Response to WSCC Strategic Planning Consultation Comments dated 30 November 2012

Proposed housing development at

Roundstone Lane, Angmering
Arun Planning Application A/82/12

12 December 2012

113

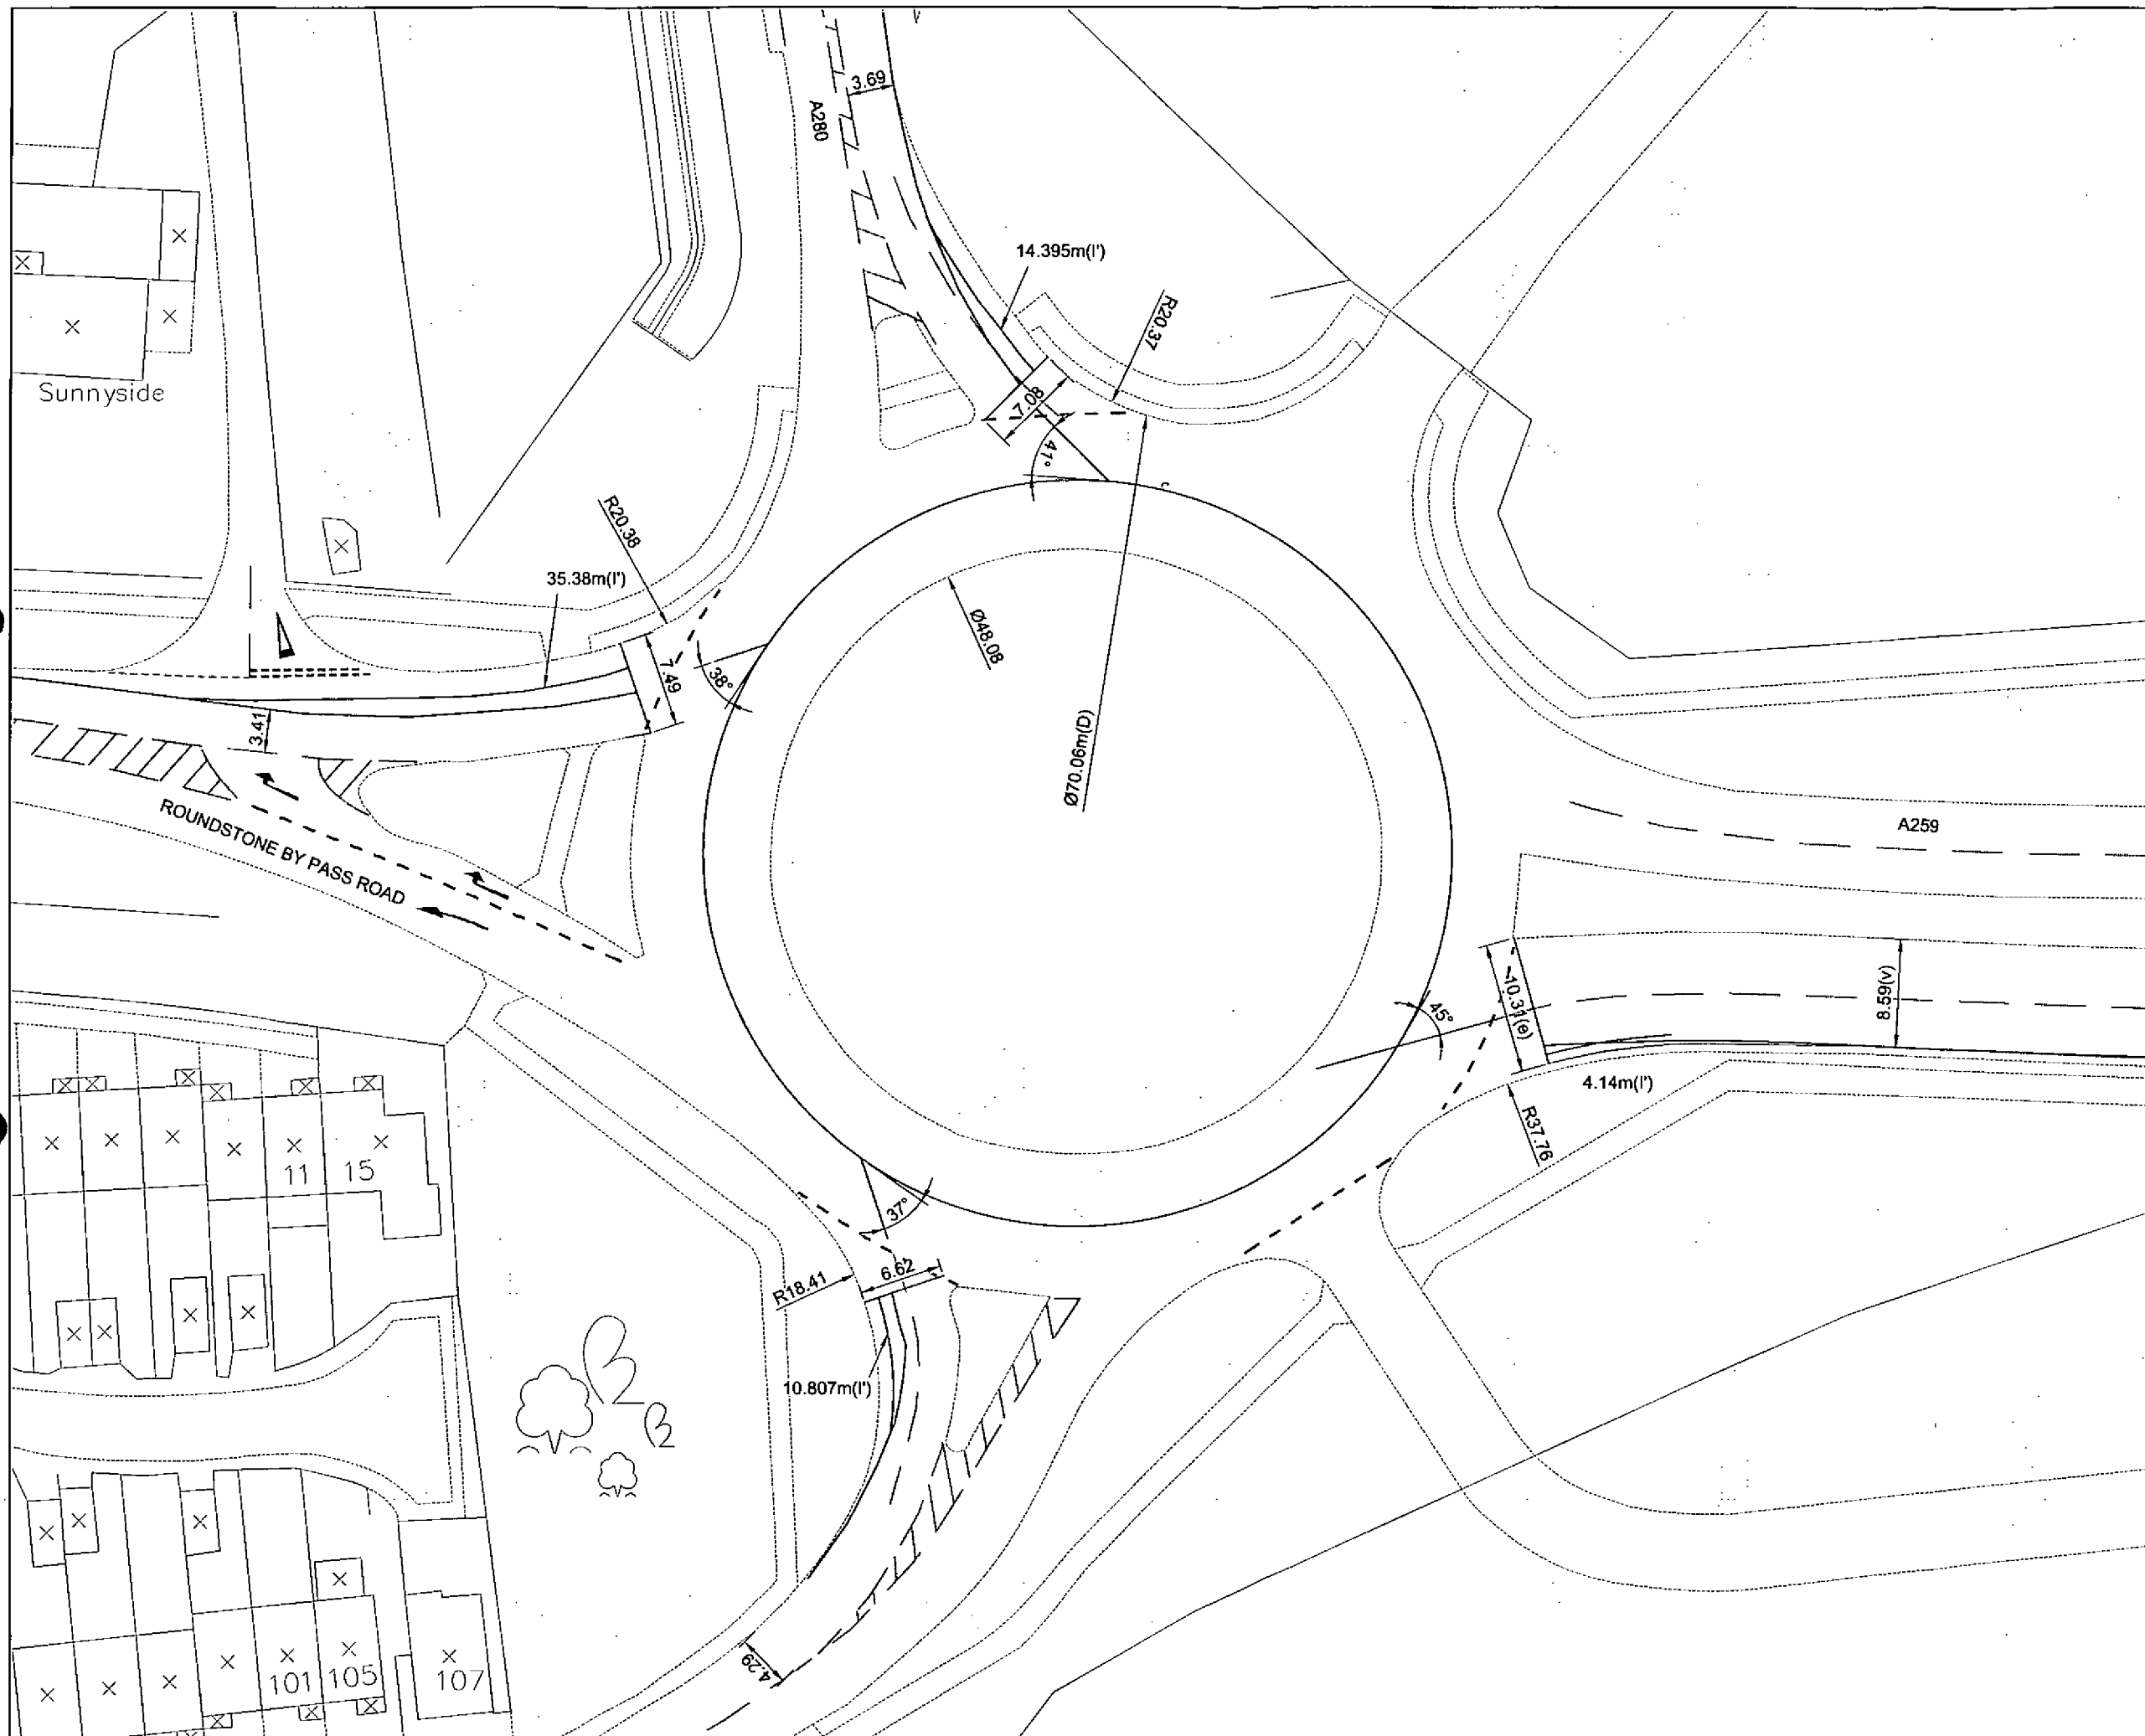
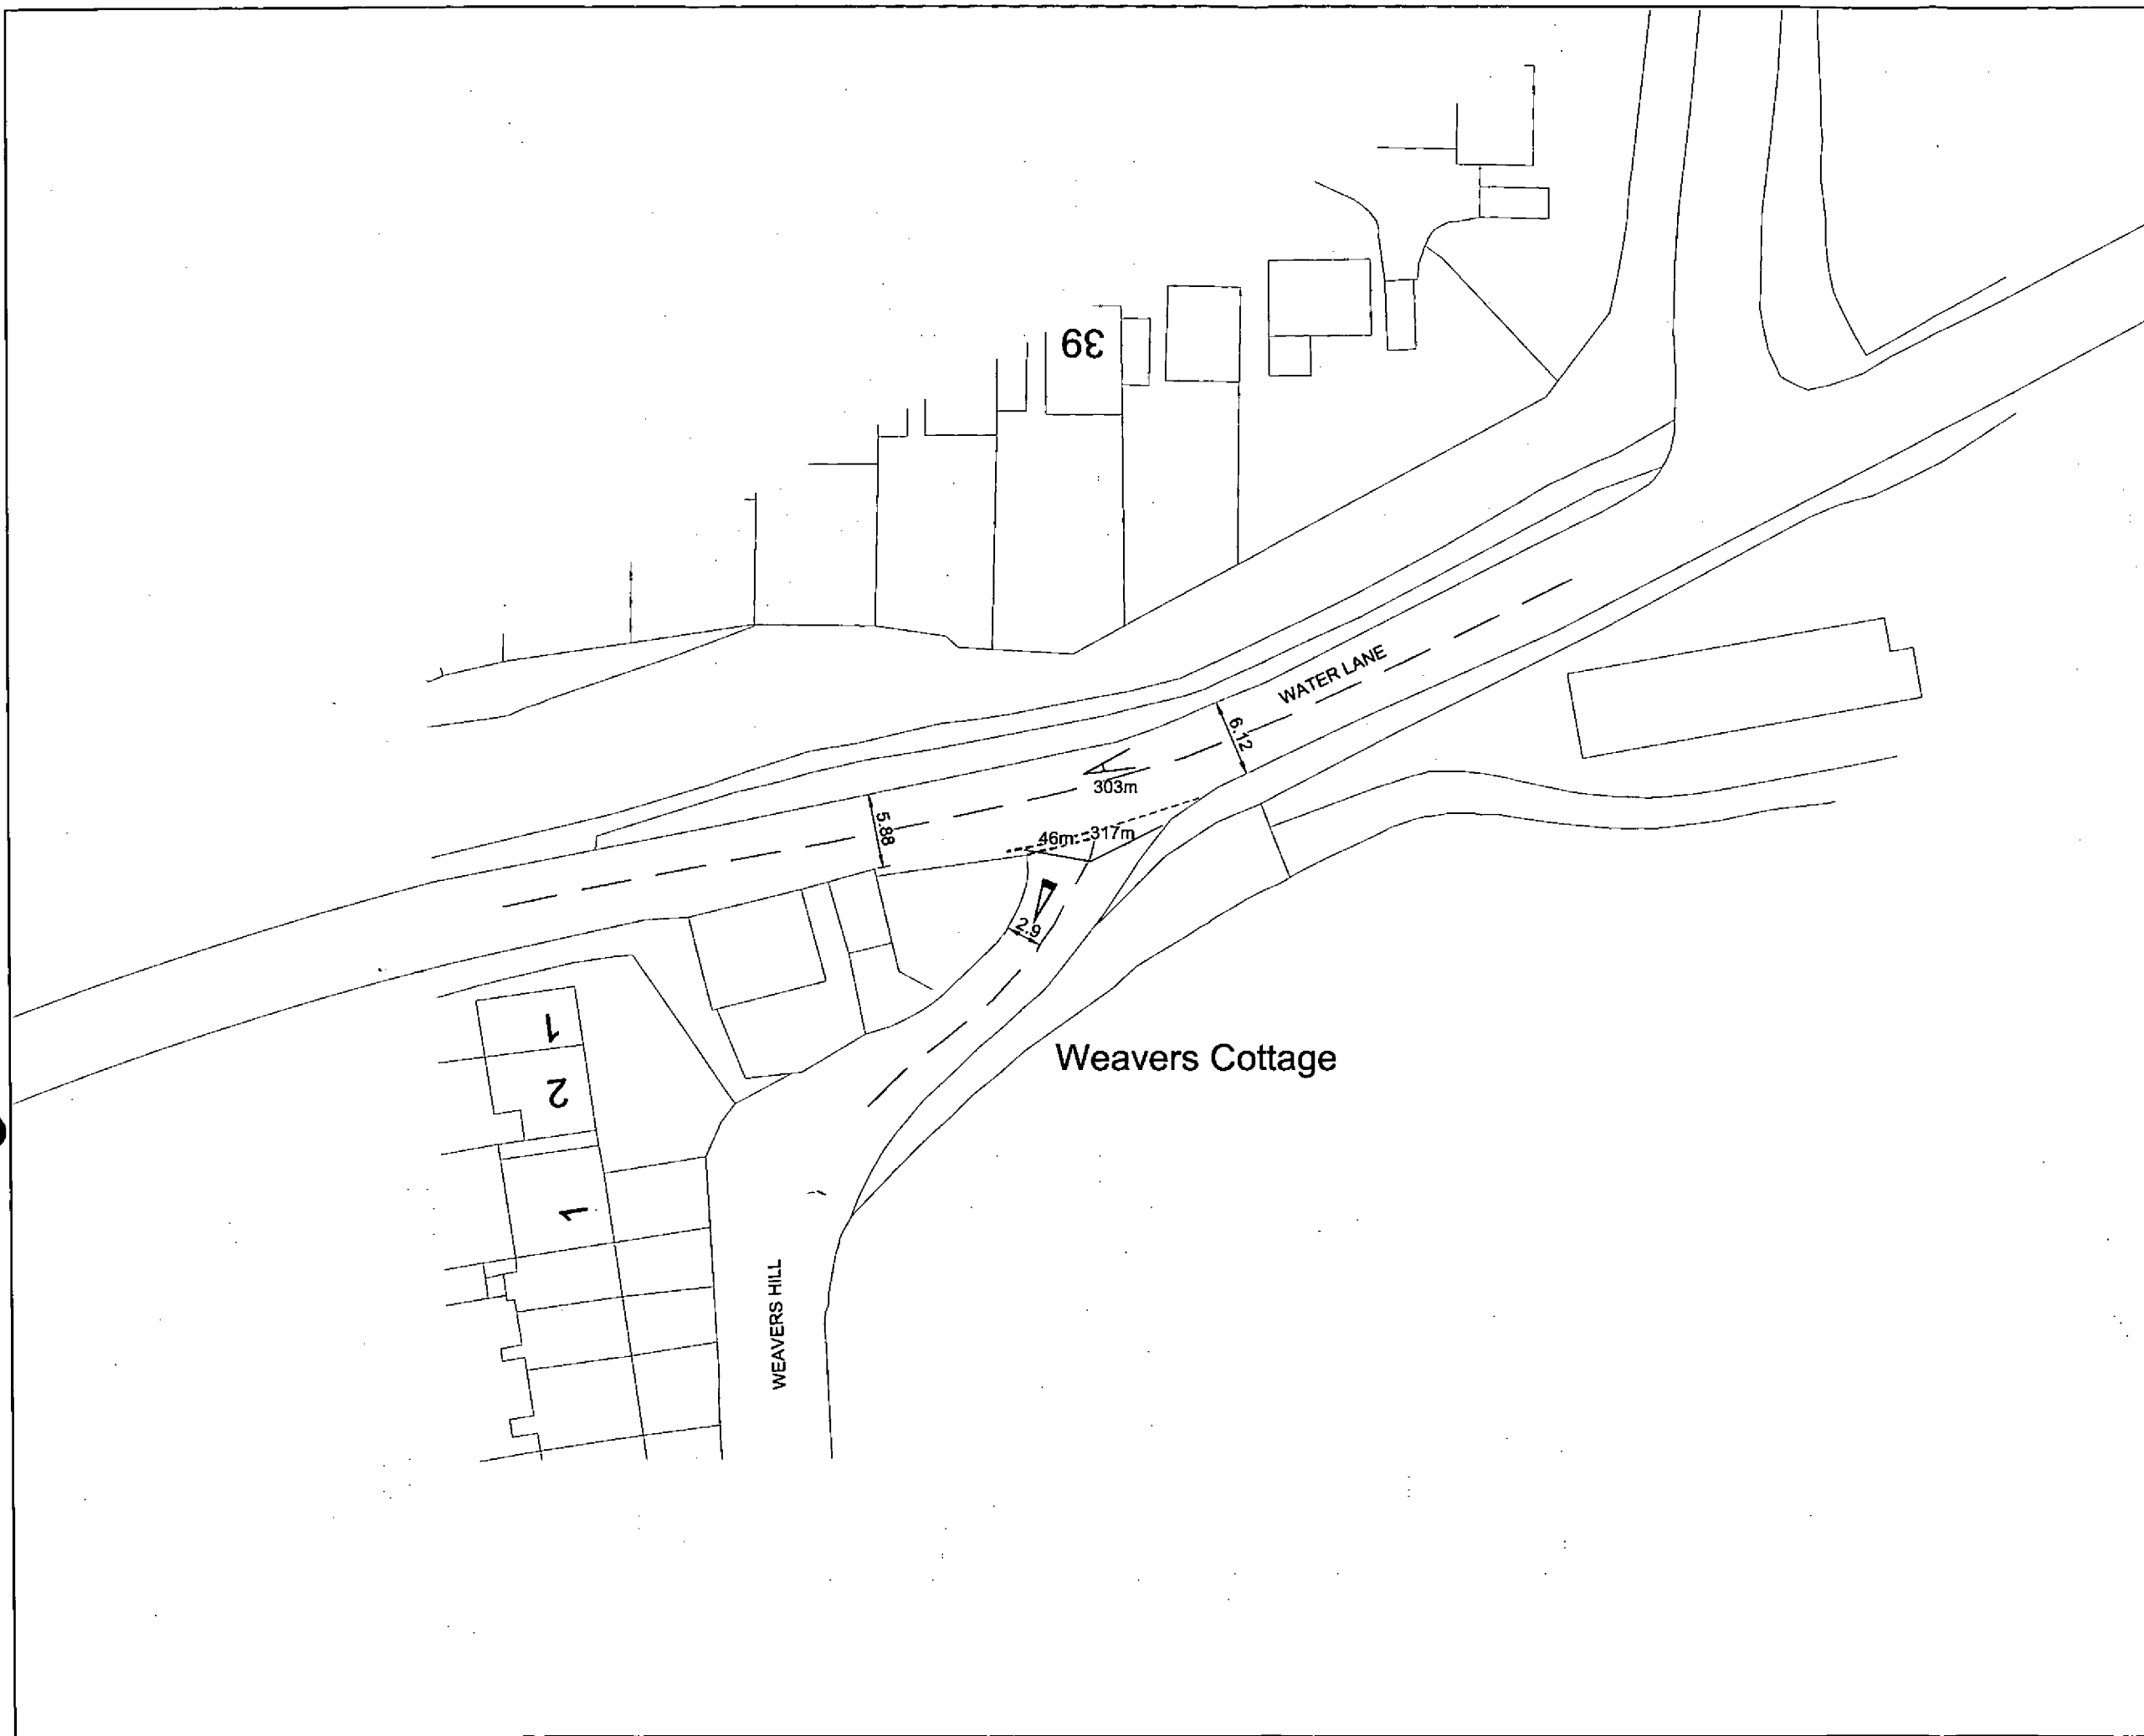
All input geometry has been rechecked and minor alteration made to the models where necessary. Drawings 22067/112 – 118 highlighting the input geometry used to analyse the Roundabouts and T junctions are attached in Appendix 1.
